From: Richard Castro-Parker
Sent: 10 December 2018 11:03
To: Planning.Responses
Subject: FW: AW/85/18/HH - 54 Kingsway material details.

AW/85/18/HH

These comments are based on revised plans, submitted in August.

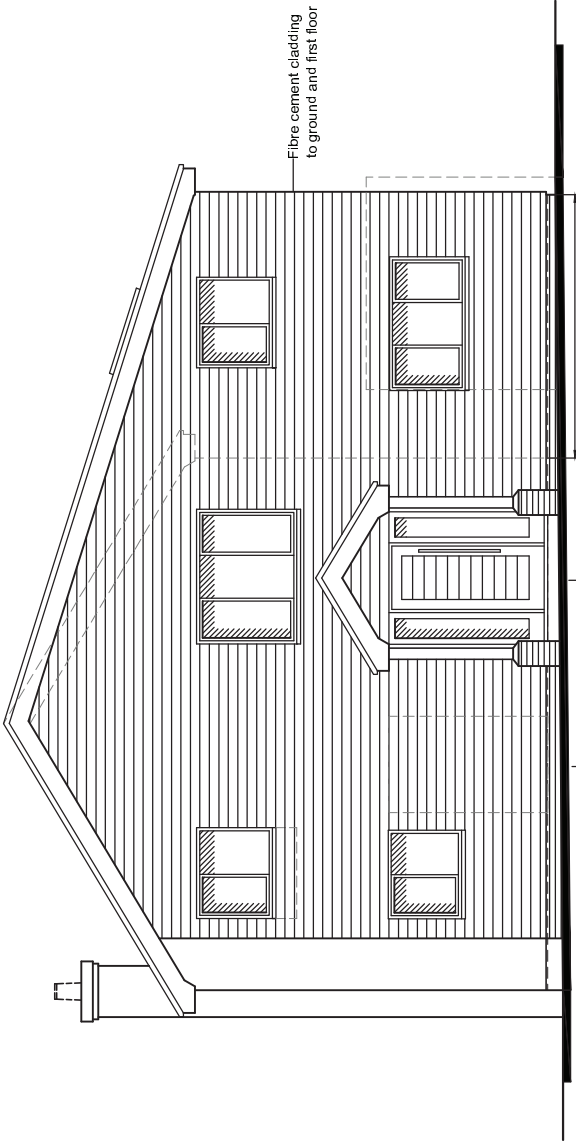
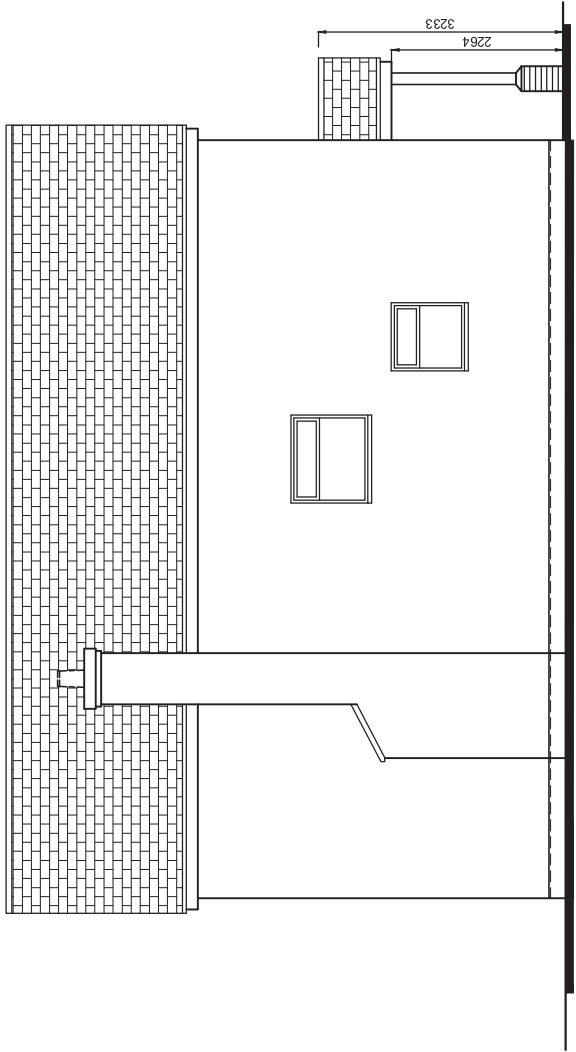
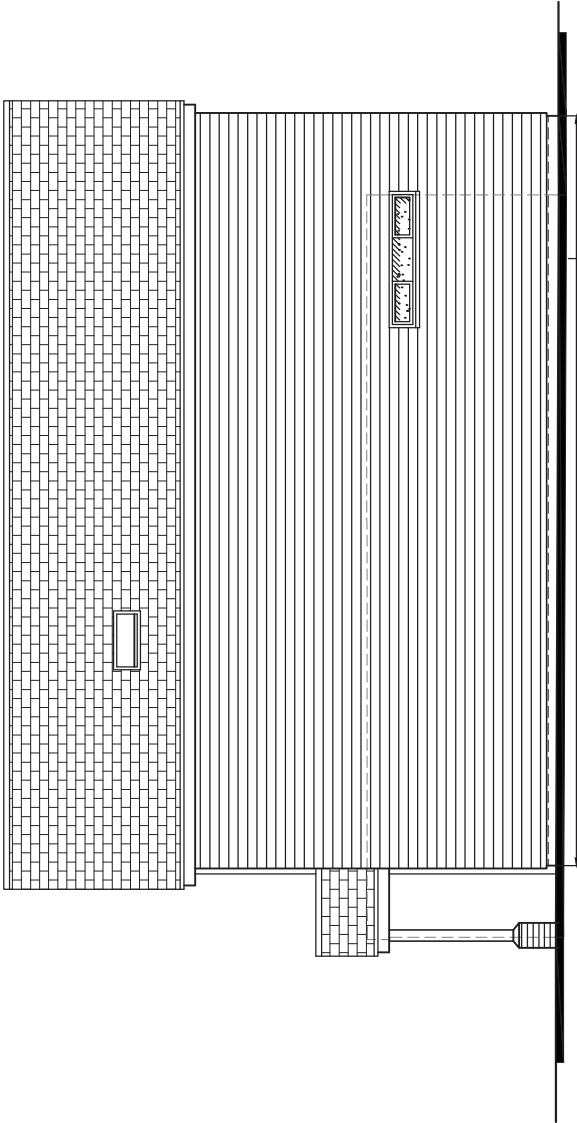
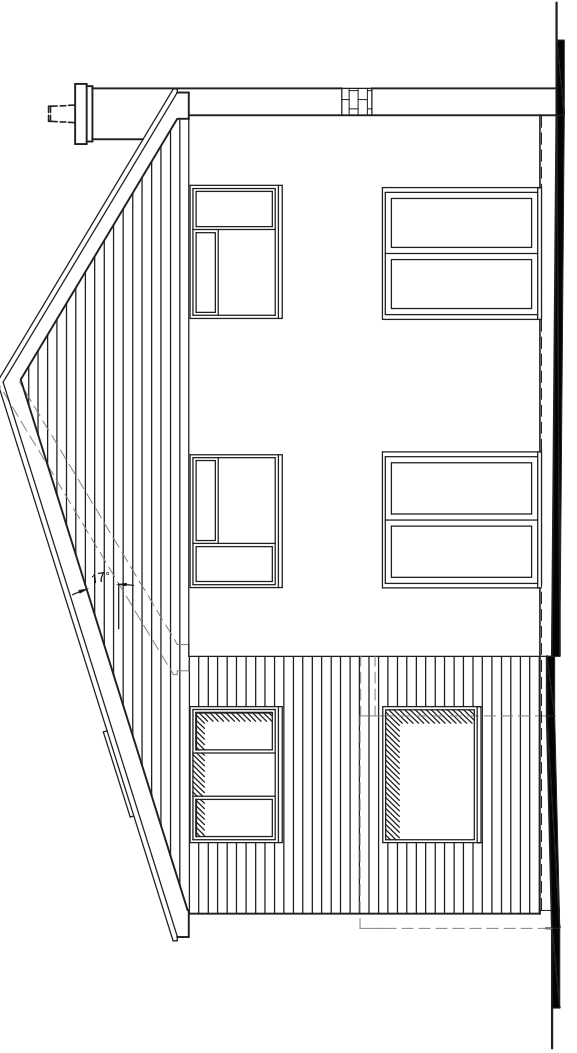
The revised two storey side extension is more in keeping with the host building in terms of its location, size and the resulting roof form.

The revised proposal is therefore considered to be more in keeping with the properties within the local area, i.e. through the use of render on the front elevation. However, it is not clear from the plans what the cladding will look like, or what colour it will be. There is also limited information as to the colour of the windows, front door, and roofing materials. Such detail will affect the impact of the proposal upon the local area, and should be provided.
